Re: Bayside Council Submission: Raymond Avenue Multi Level Warehouse Matraville (SSD-31552370)

Thank you for your email dated 11 July 2022 attaching the applicant's Response to Submissions (RTS) regarding the State Significant Development (SSD) for a Warehouse and Distribution Facility at 42-52 Raymond Avenue and 44A McCauley Street, Matraville.

Council staff have reviewed the RTS prepared by the Applicant in response to the issues raised in Council's submission dated 10 May 2022, and provide the following feedback.

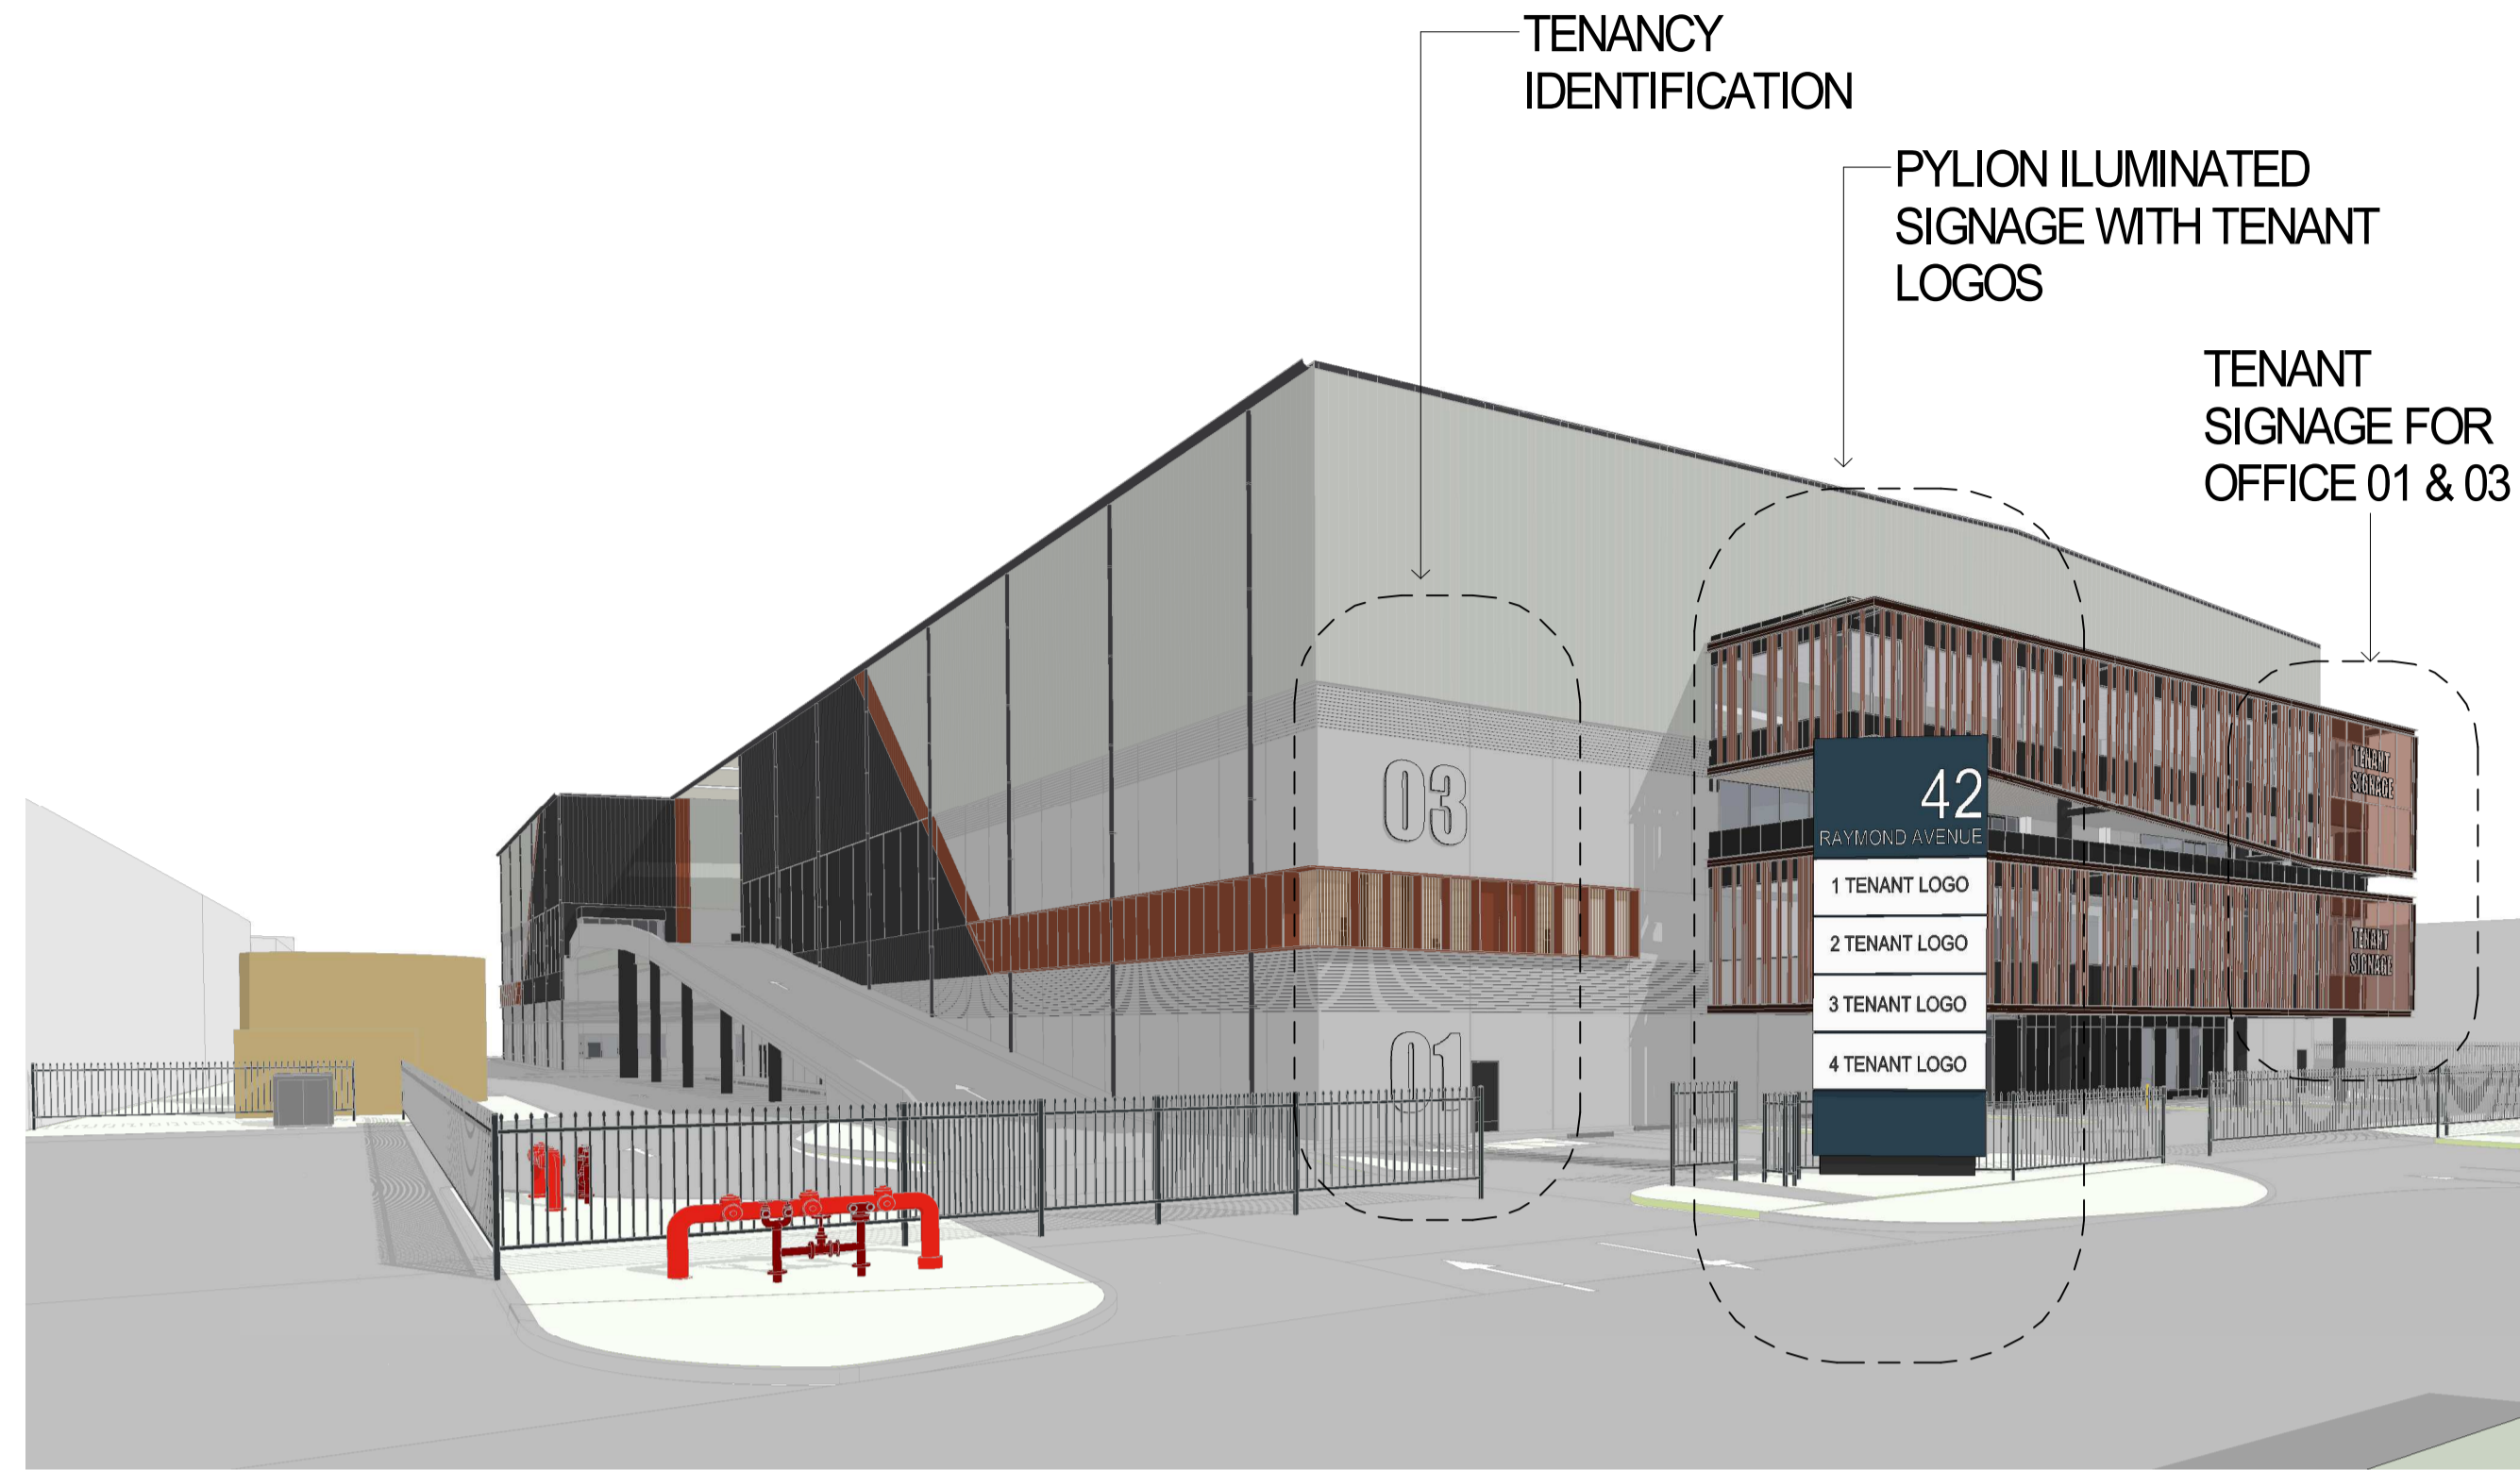
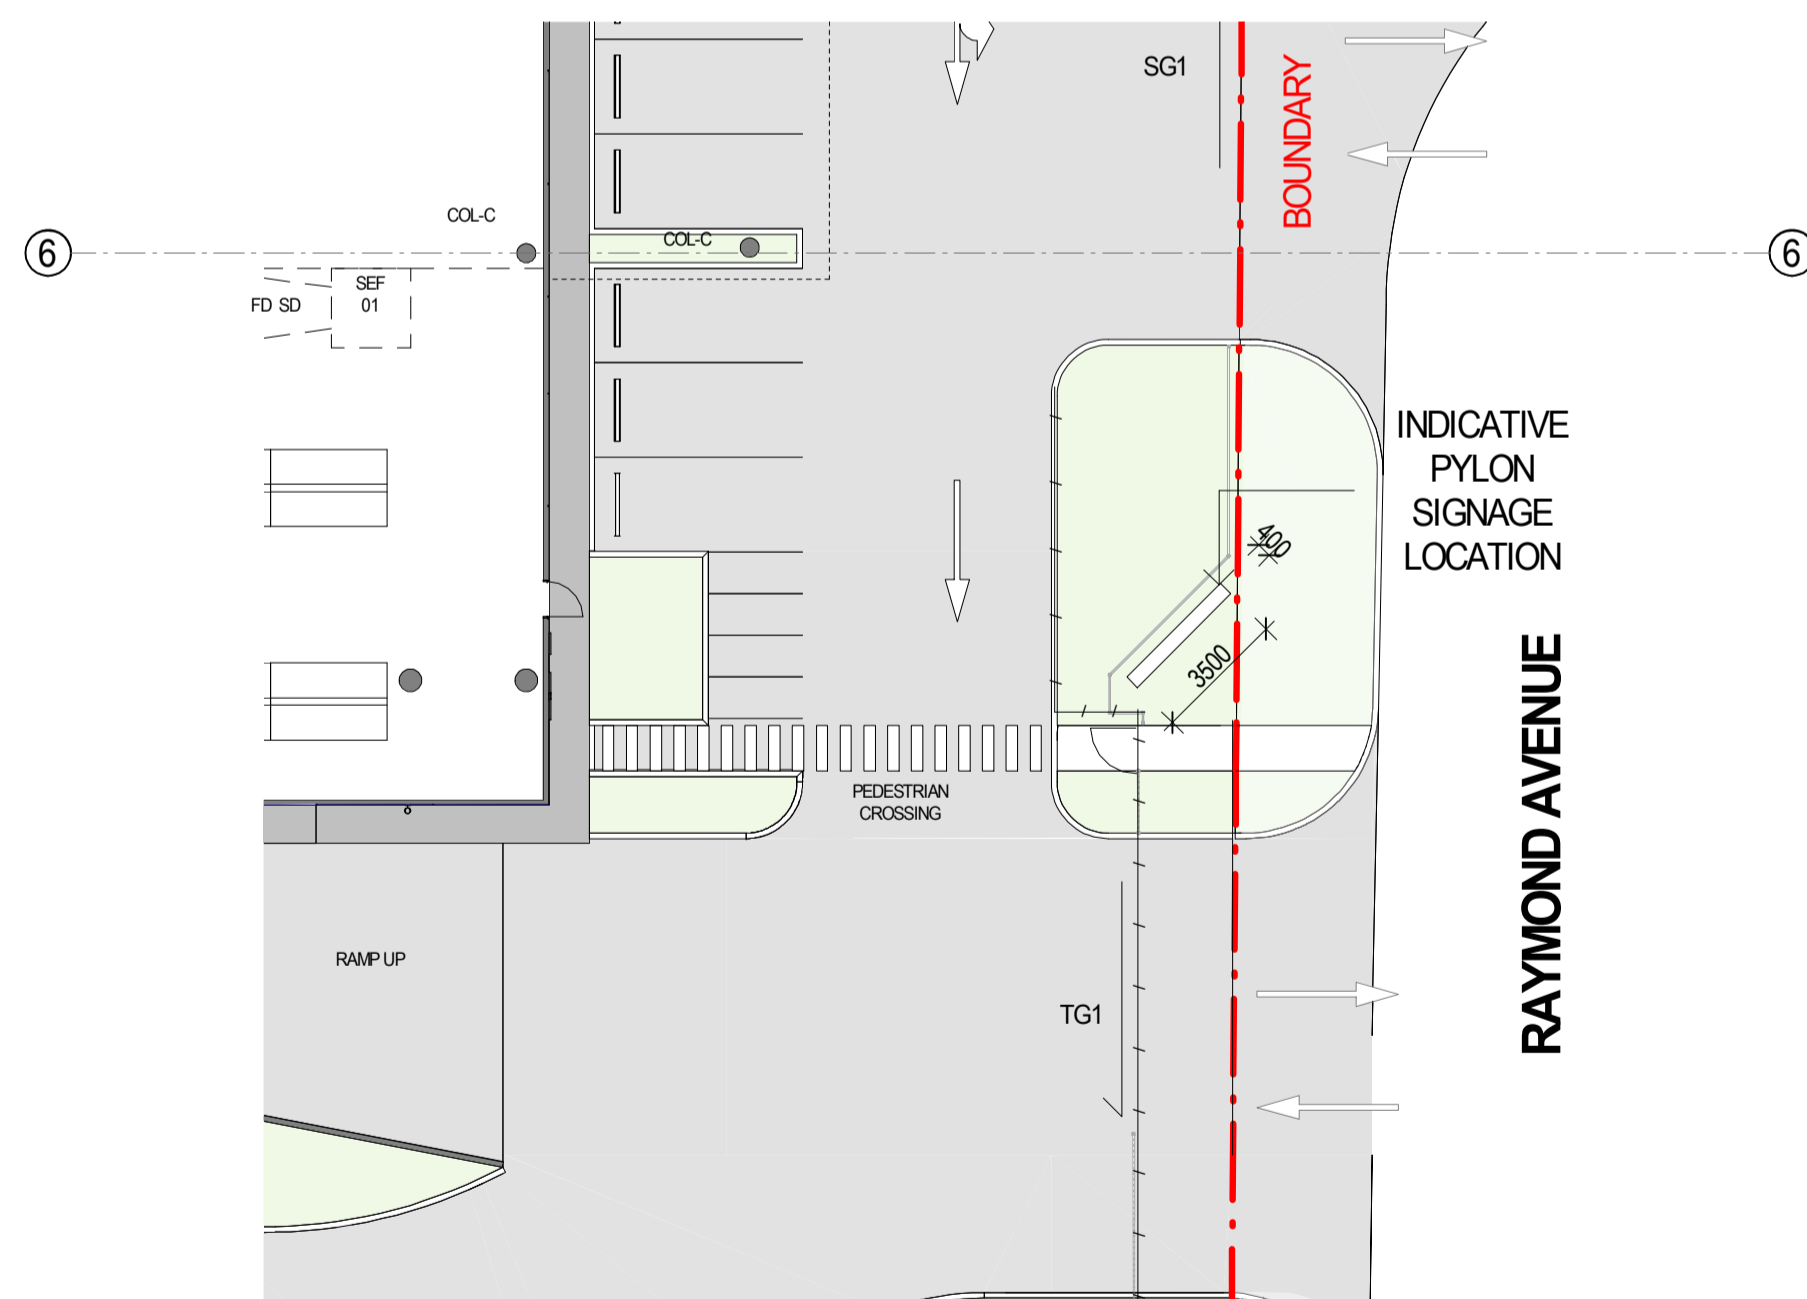
The RTS notes that as the facility is operating 24/7, it is important to provide illuminated wayfinding signage on entry that will allow occupiers to identify the site at night. This illumination is currently restricted to the immediate signage, and therefore will have minimal adverse effect on the surrounding neighbours and residents.

- The illuminated signage is not to be animated/flashing to ensure neighbourhood amenity is maintained.

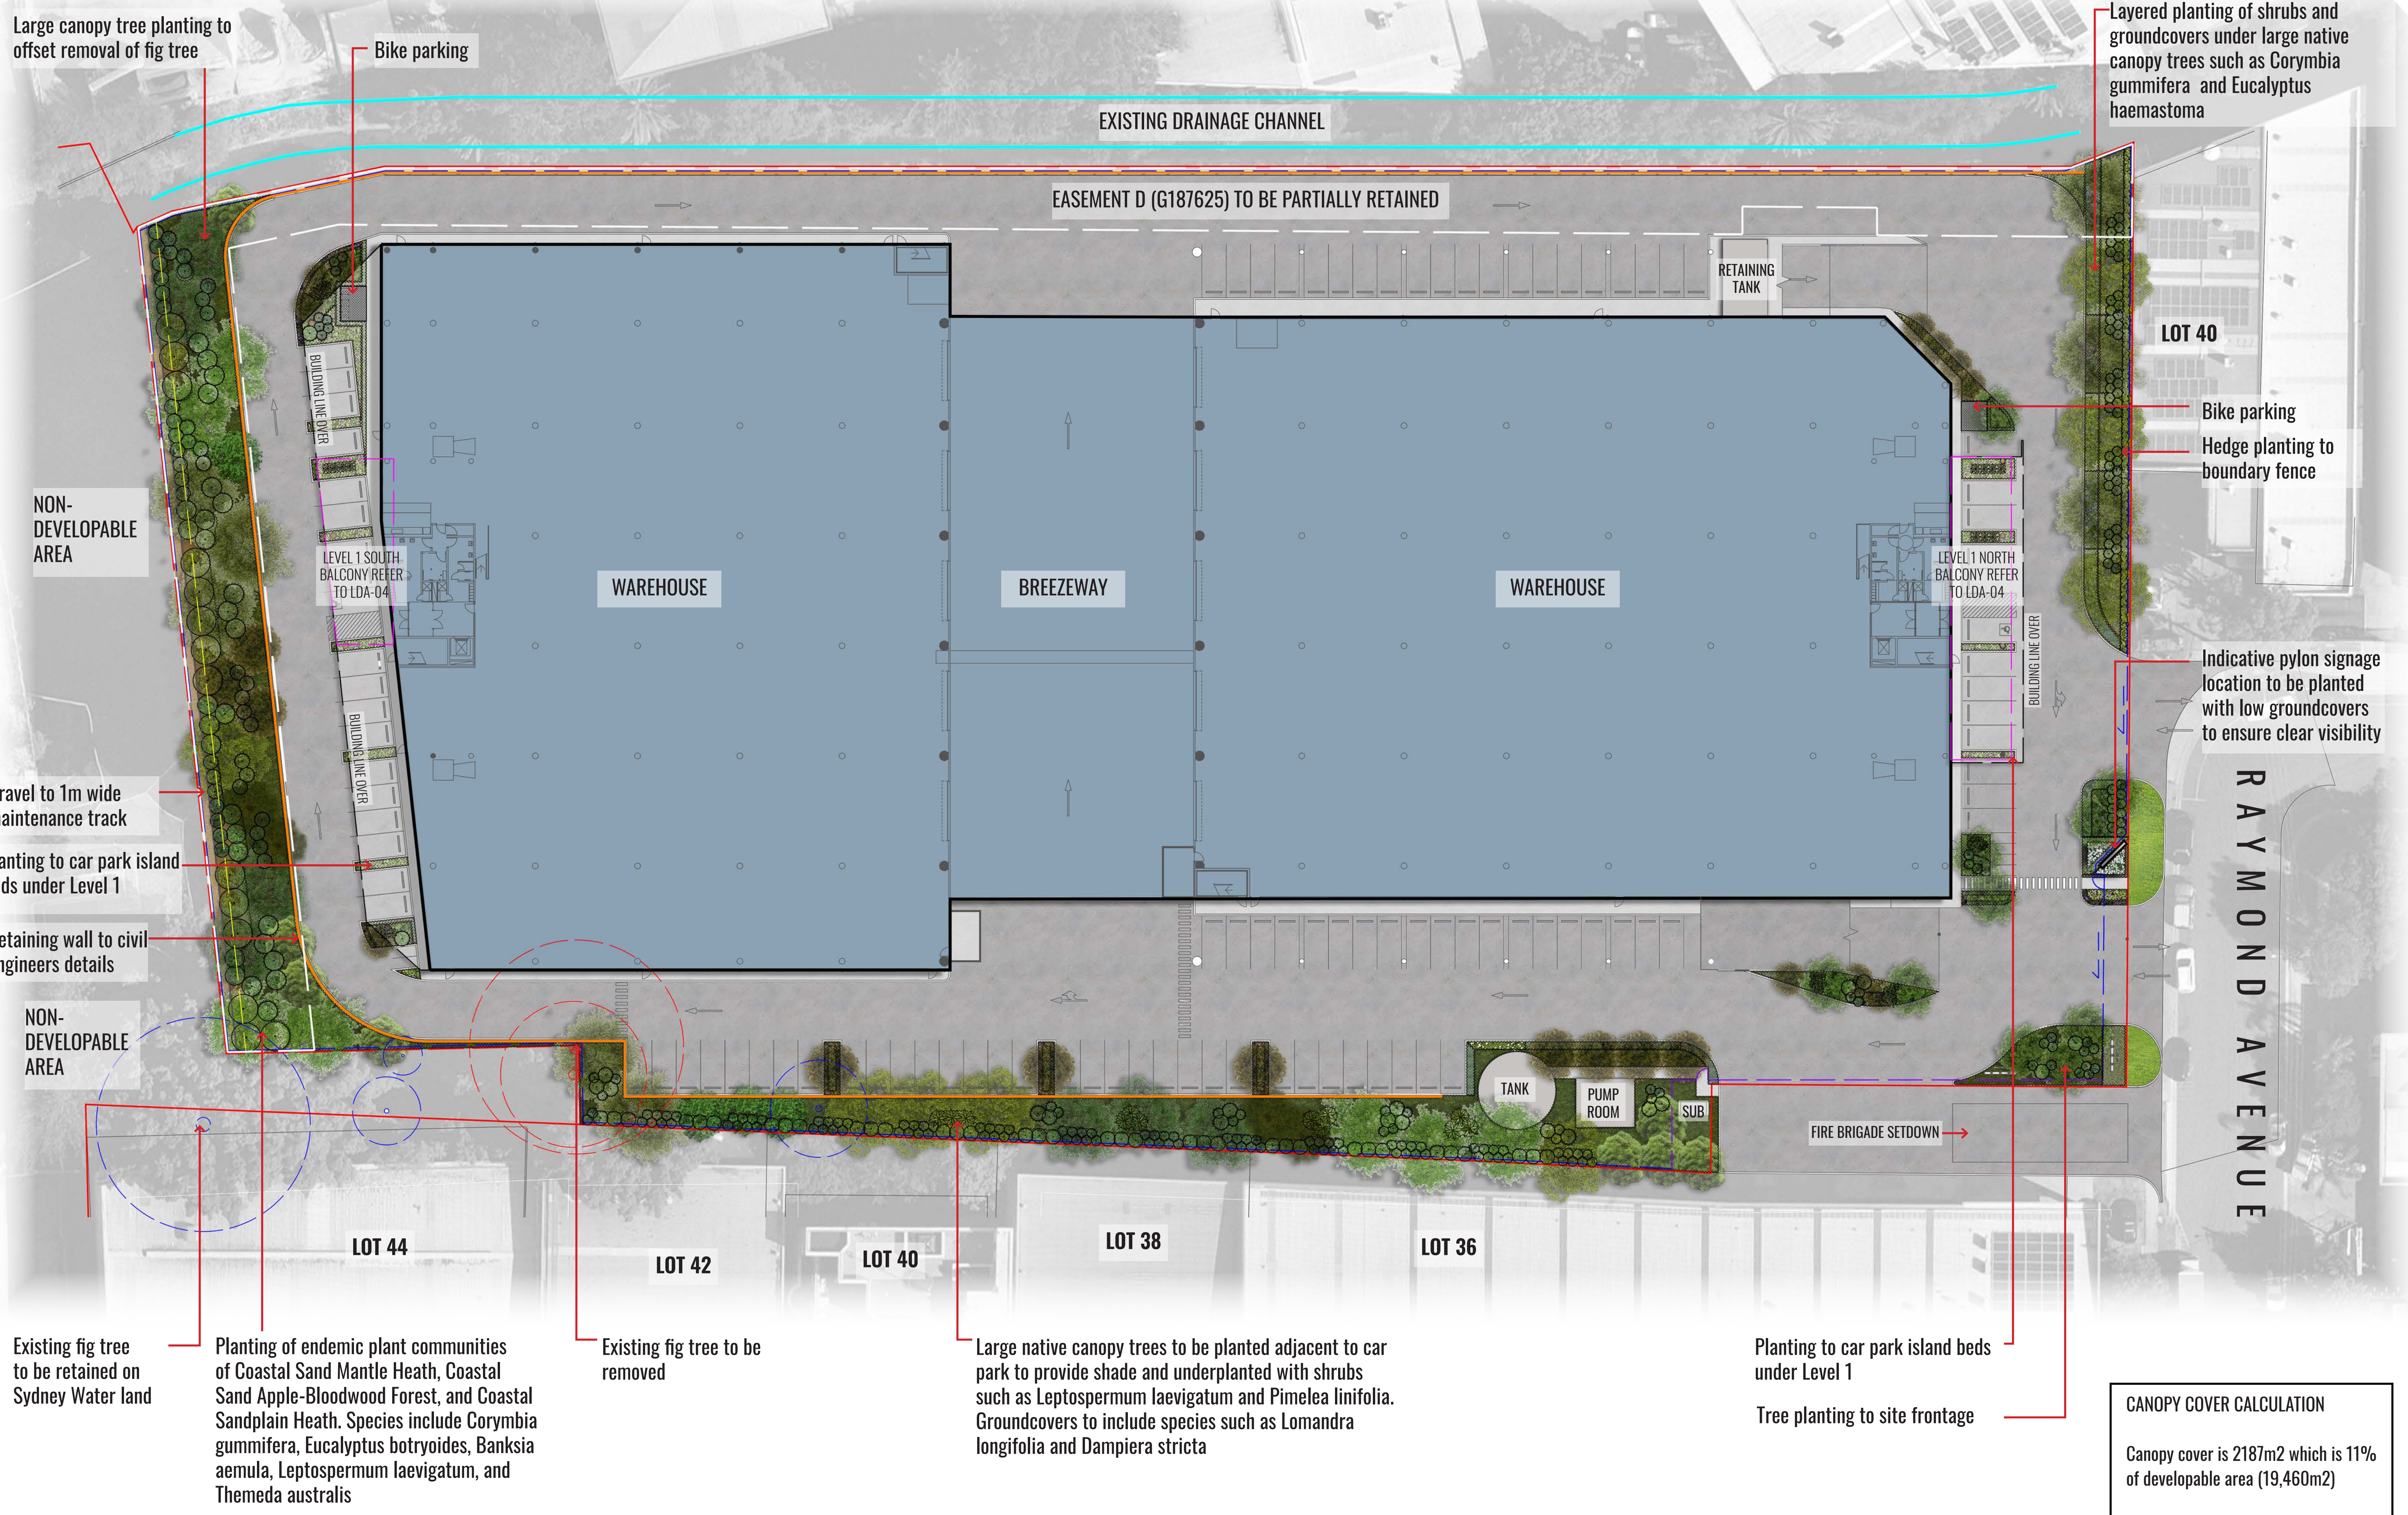
The RTS concludes that the visual impact of the development of the north west site boundary is limited, and is addressed through the inclusion of the new articulated façade, as well as the inclusion of additional planting along the north-western site boundary.

- Additional planting and landscaping to be provided along the north-western site boundary to soften and screen the development from the surrounding site.
